Rampion 2 Wind Farm

Environmental Statement

Volume 4, Appendix 15.1: Sea scape, Landscape and Visual Im pact Assessment consultation responses

Document Reference: 6.4.15.1

Figure 15.33i  
 Viewpoint 8: Brighton sea front promenade

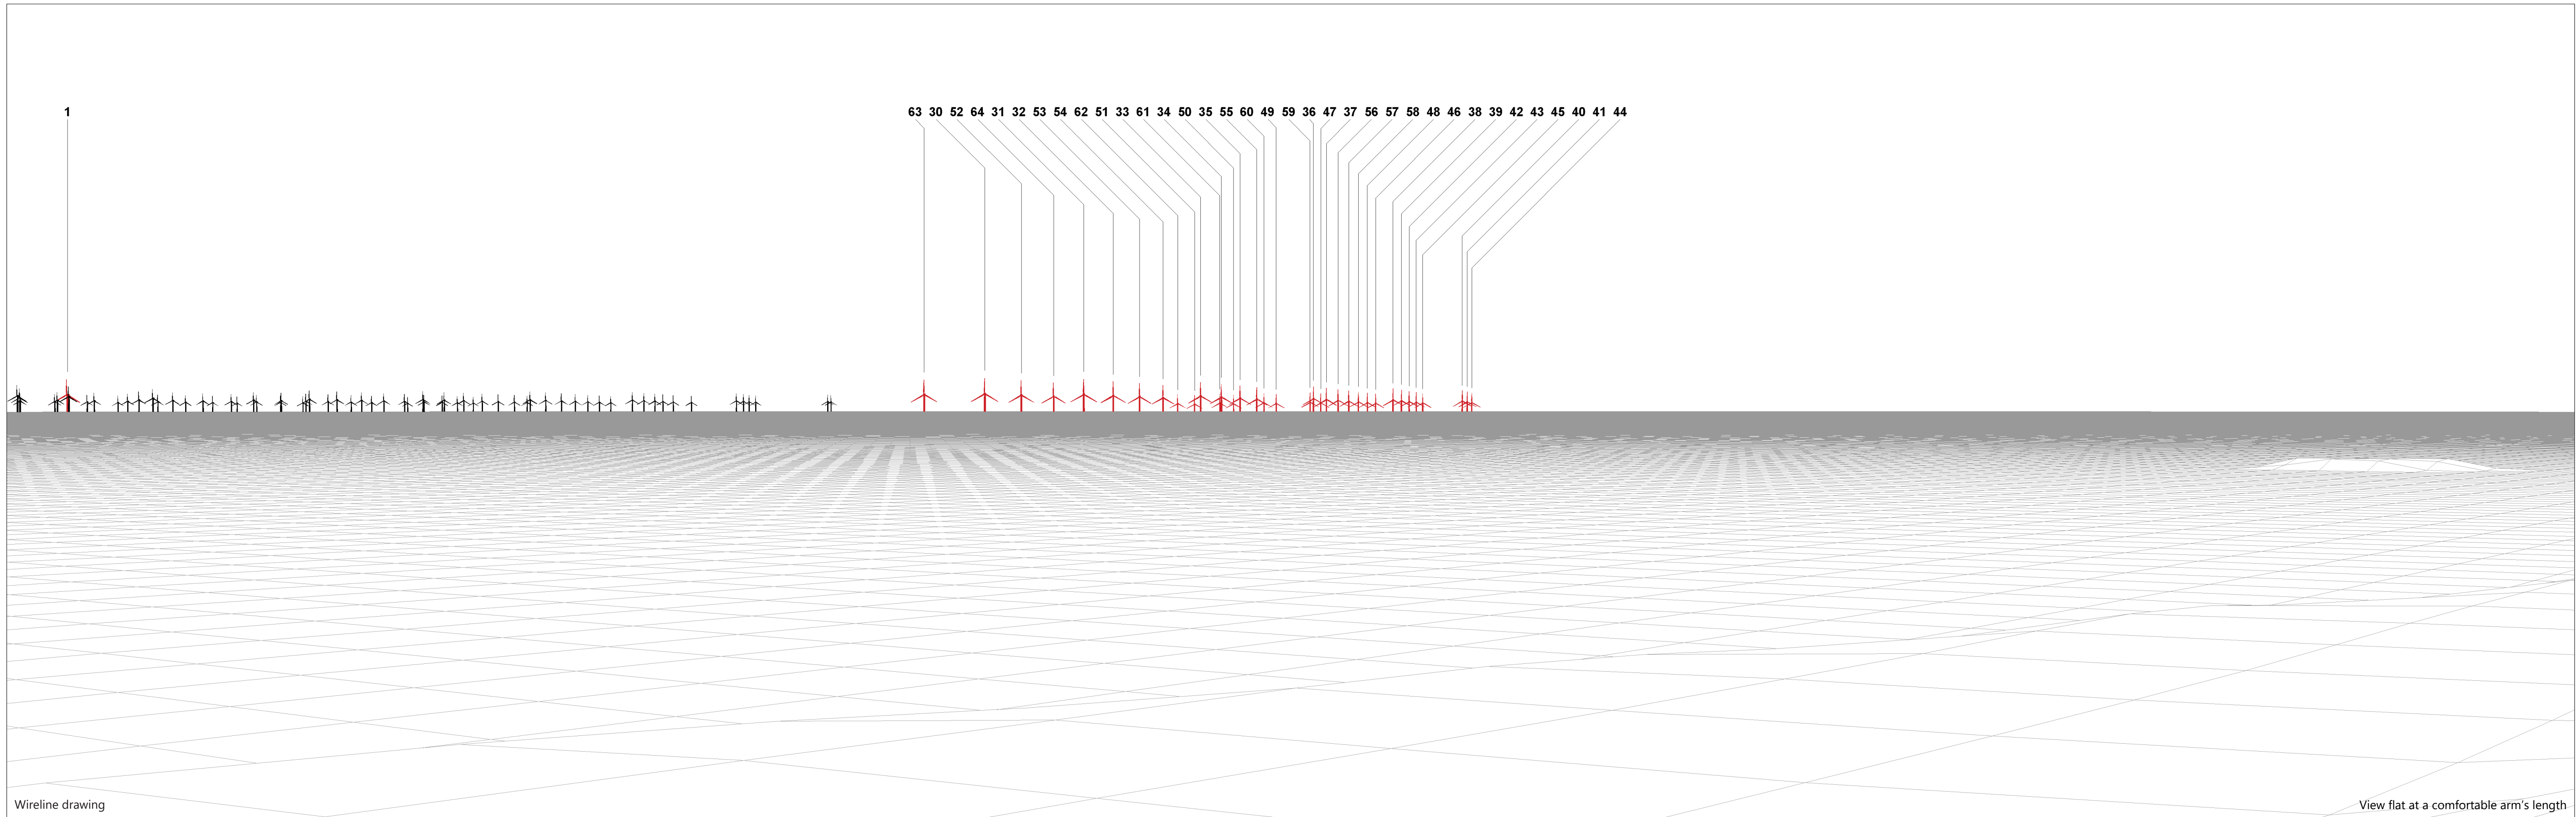
Consultee	Date / Document	Scoping Opinion Comment	How this is addressed in this ES
			Volume 4 of the ES (Document Reference 6.4.15.4).
Brighton and Hove City Council	Scoping Opinion August 2020	With regard to section 5.13 on 'Seascape, landscape and visual', in terms of viewpoints, the comments of the County Landscape Architect are agreed with.	Noted.
Brighton and Hove City Council	Scoping Opinion August 2020	Brighton, Hove and Rottingdean are the closest coastal settlements to the scoped array area according to the Report, yet only two viewpoints from within the B&H area have been selected. The Report says (para. 5.13.92) that "it is also considered that there is also now familiarity with the visual effects of Rampion 1, such that people will be better able to visualise the effects of Rampion 2 based on fewer viewpoints". However, given that the proposed turbines would be more than twice the height of the Rampion 1 turbines I do not think that this is necessarily the case. I would certainly agree with the County Landscape Architect that a view from Hollingbury Golf Course, given its proximity to the scheduled monument, should be reinstated. I also consider that R1 viewpoint 11, from Marine Parade, should also be reinstated given its elevated position and wealth of designated heritage assets.	Viewpoints selected for the SLVIA are presented in Chapter 15: Seascape, landscape and visual impact assessment, Volume 2 of the ES (Document Reference 6.2.15), Section 15.6 and Table 15-14 and assessed in full in Appendix 15.4: Viewpoint assessment, Volume 4 of the ES (Document Reference 6.4.15.4), which include views from Brighton seafront (Viewpoint 8), Rottingdean (Viewpoint 7) and Hollingbury Golf Course (Viewpoint 27).

Figure 15.34g  
 Viewpoint 9: Shoreham A259 coastal road

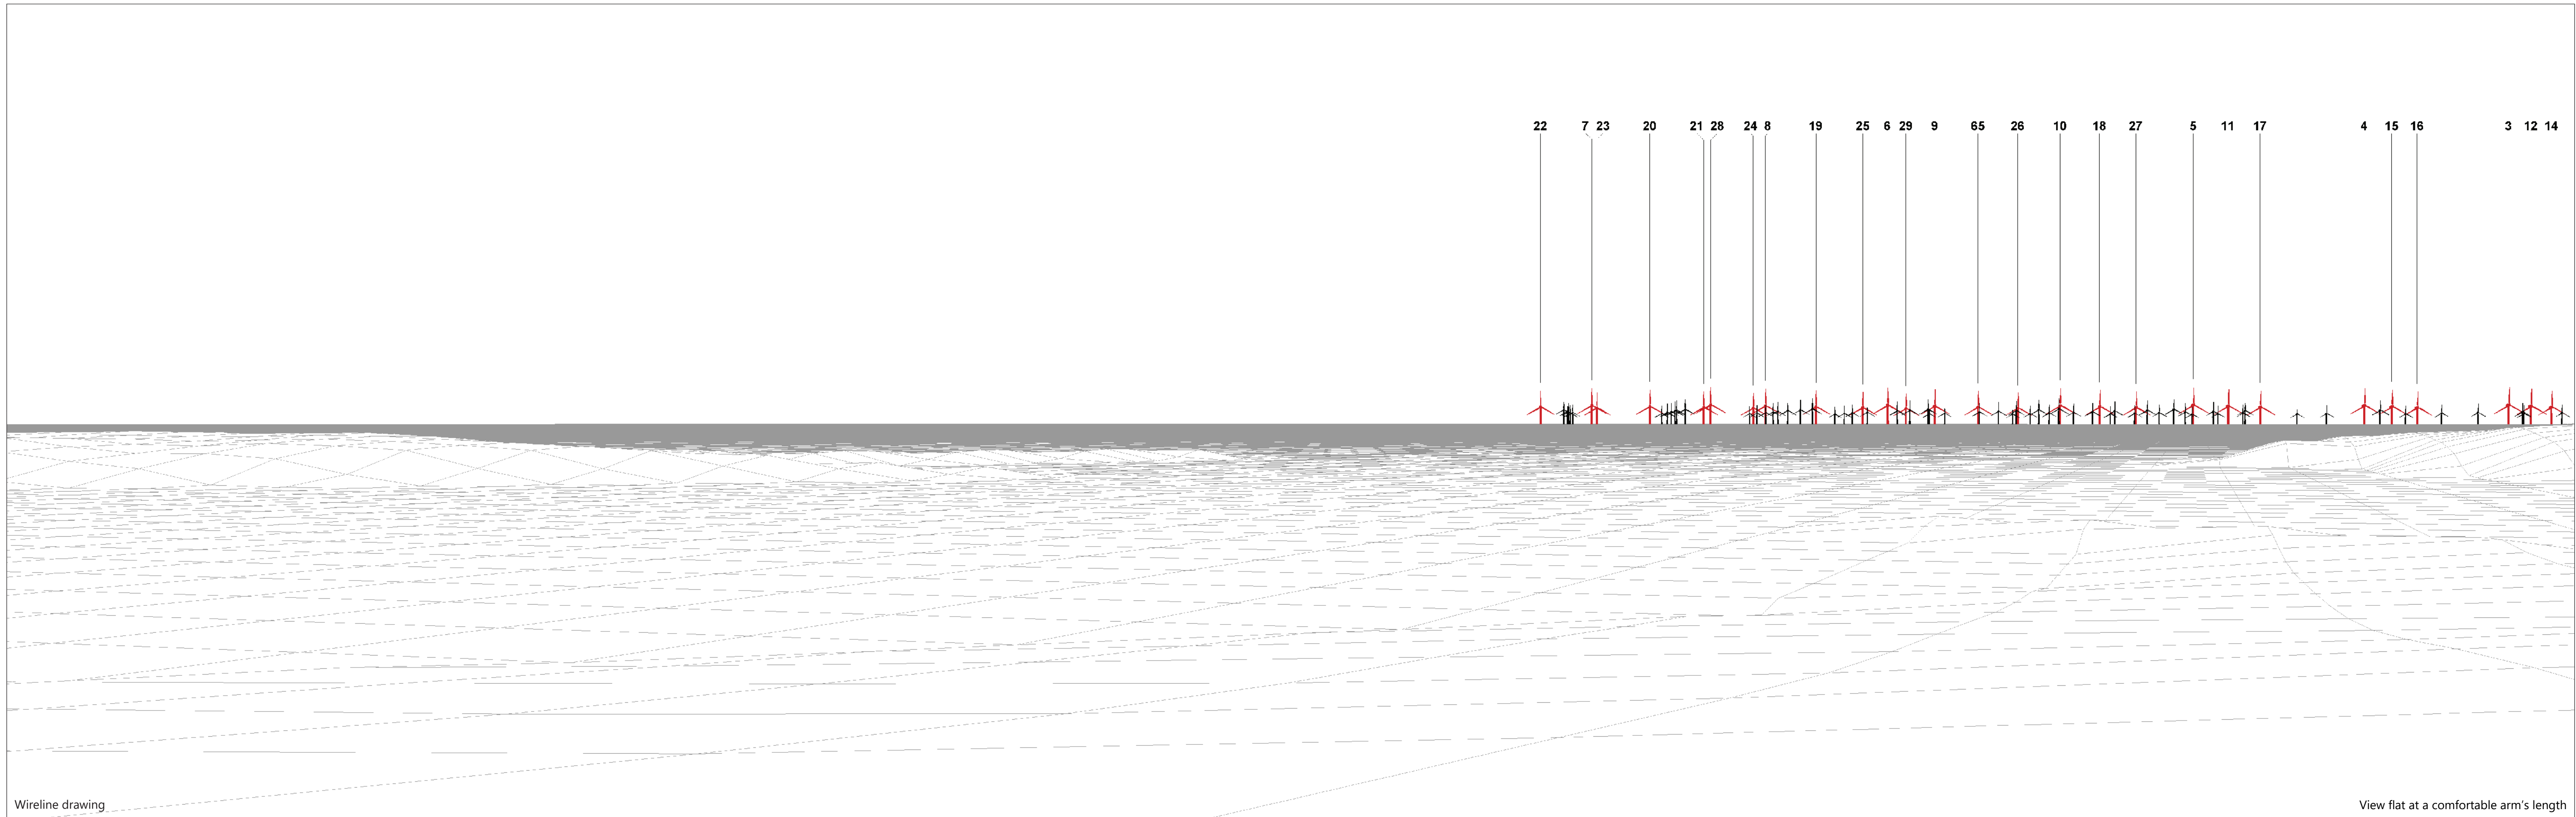
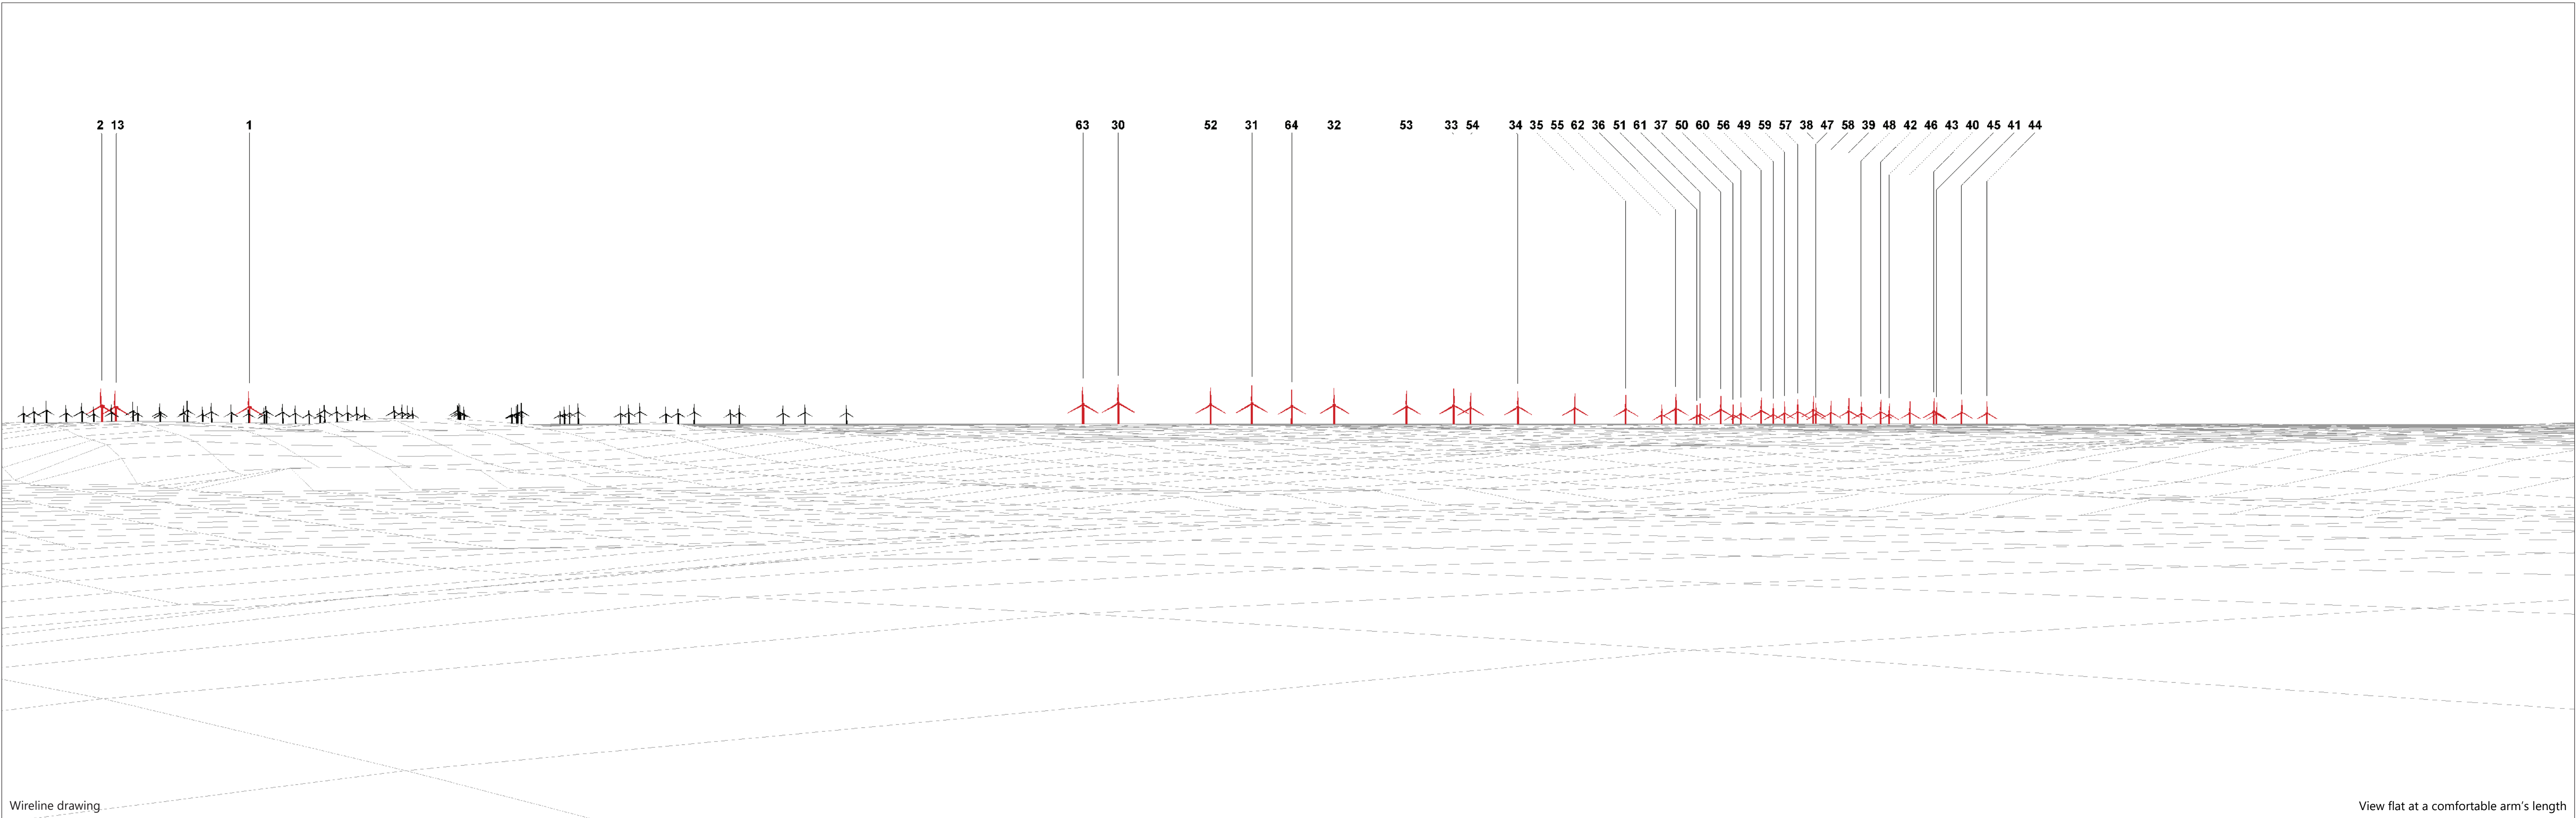
Historic England	Viewpoint Selection Method Statement November 2020	<p>Support of chosen viewpoints</p> <p><u>Viewpoint 9:</u> We support the choice of viewpoint 9 over 60. Viewpoint 9 is very close to Shoreham Fort which is a scheduled monument, and considered an exemplar of its type. Viewpoint 9 will therefore additionally provide us with a suitable understanding of visual impact on the Fort.</p> <p><u>Viewpoint 11:</u> We support the choice of viewpoint 11 over 40. Viewpoint 11 is very close to Littlehampton Fort which is a scheduled monument, and (like Shoreham Fort) is considered an</p>	Noted.

Figure 15.50h
 Viewpoint 27: Hollingbury Golf Course/Hill Fort

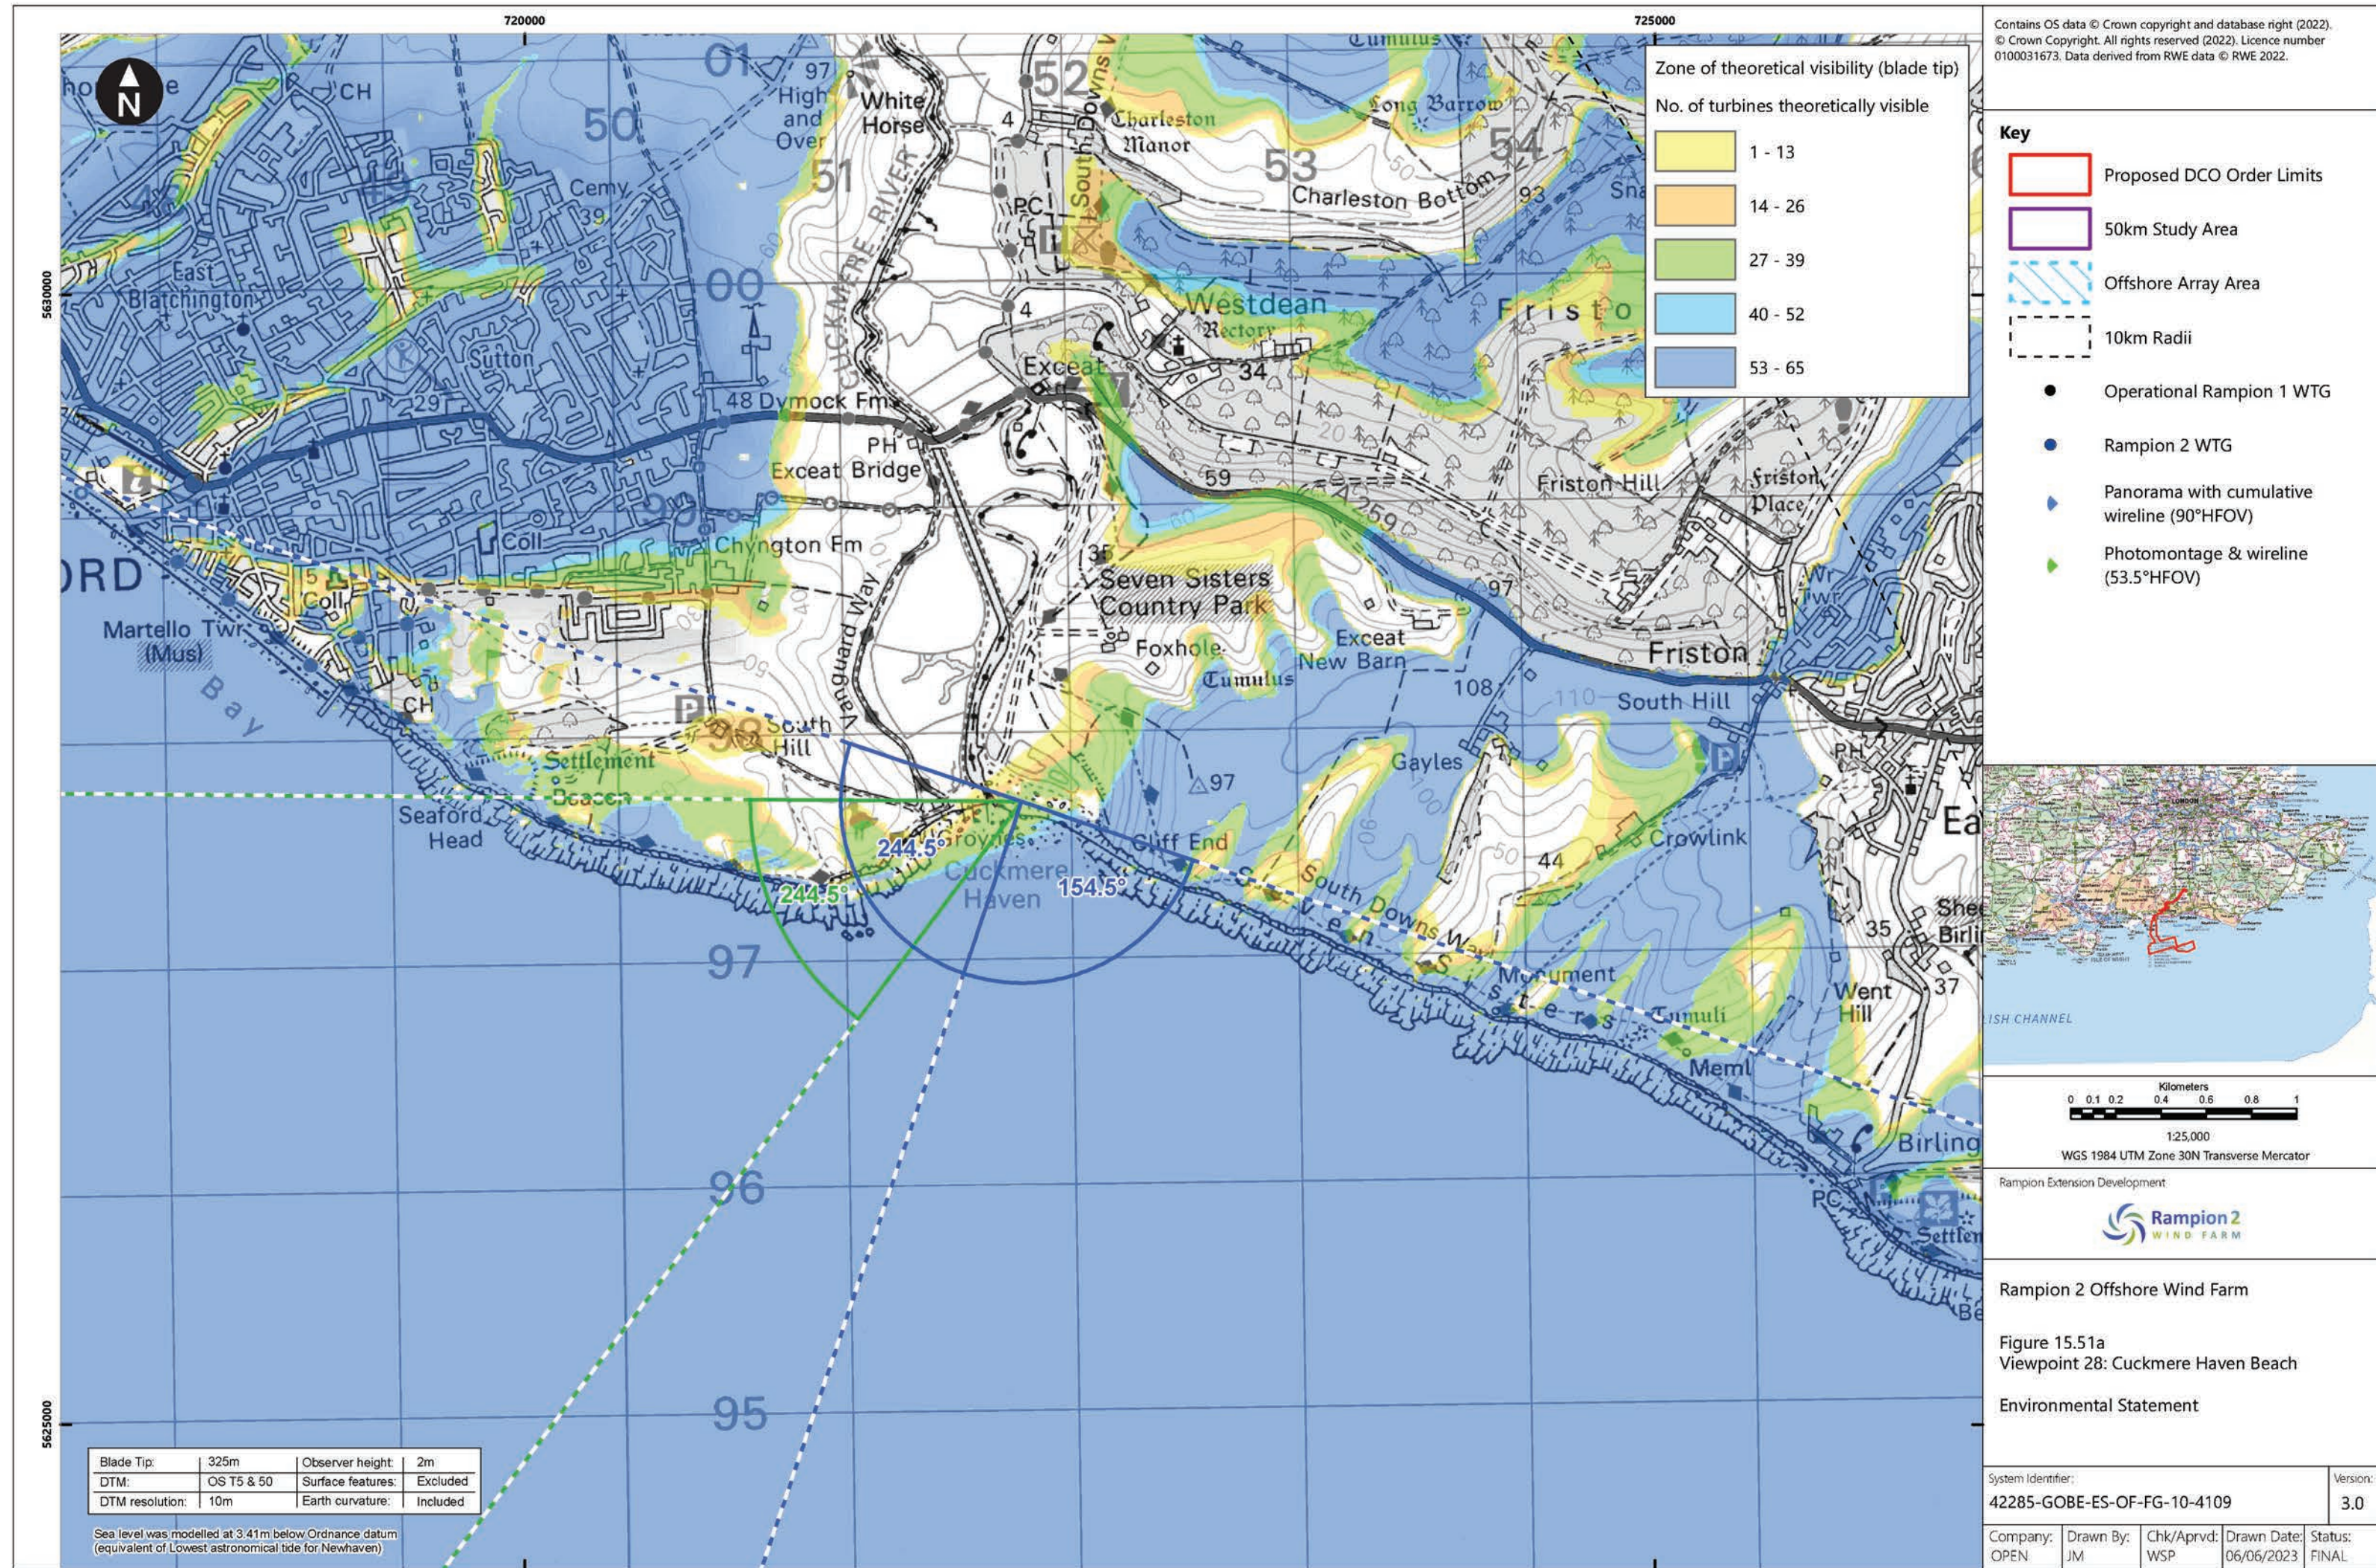
Consultee	Date / Document	Scoping Opinion Comment	How this is addressed in this ES
Brighton and Hove City Council	Scoping Opinion August 2020	Viewpoints which have been excluded for various reasons and it is recommended they are assessed: <ul style="list-style-type: none"> • Ditchling Beacon • Hollingbury Golf Course • Newhaven ferry or if not a key view from an area of the sea within the study area used for recreational boating such as sailing or fishing. 	Viewpoints selected for the SLVIA are presented in Chapter 15: Seascape, landscape and visual impact assessment, Volume 2 of the ES (Document Reference 6.2.15), Section 15.6 and Table 15-14 and assessed in full in Appendix 15.4: Viewpoint assessment, Volume 4 of the ES (Document Reference 6.4.15.4), which include views from Ditchling Beacon, Hollingbury Golf Course and Newhaven.
Brighton and Hove City Council	Scoping Opinion August 2020	The zone of theoretical visibility diagrams indicates that there could be areas of the High Weald AONB and the low weald in East Sussex where the development would be seen. Although these are distant it would be helpful to have assessment from these viewpoints where the development may be seen.	ZTV shown in Figure 15.14a-b, Volume 3 the ES (Document Reference 6.3.15). Viewpoints from High Weald AONB (Viewpoint 47, Figure 15.62, Volume 3 of the ES (Document Reference 6.3.15)) and Low Weald (Viewpoint 26, Figure 15.49, Volume 3 the ES (Document Reference 6.3.15)) assessed in Appendix 15.4: Viewpoint assessment,
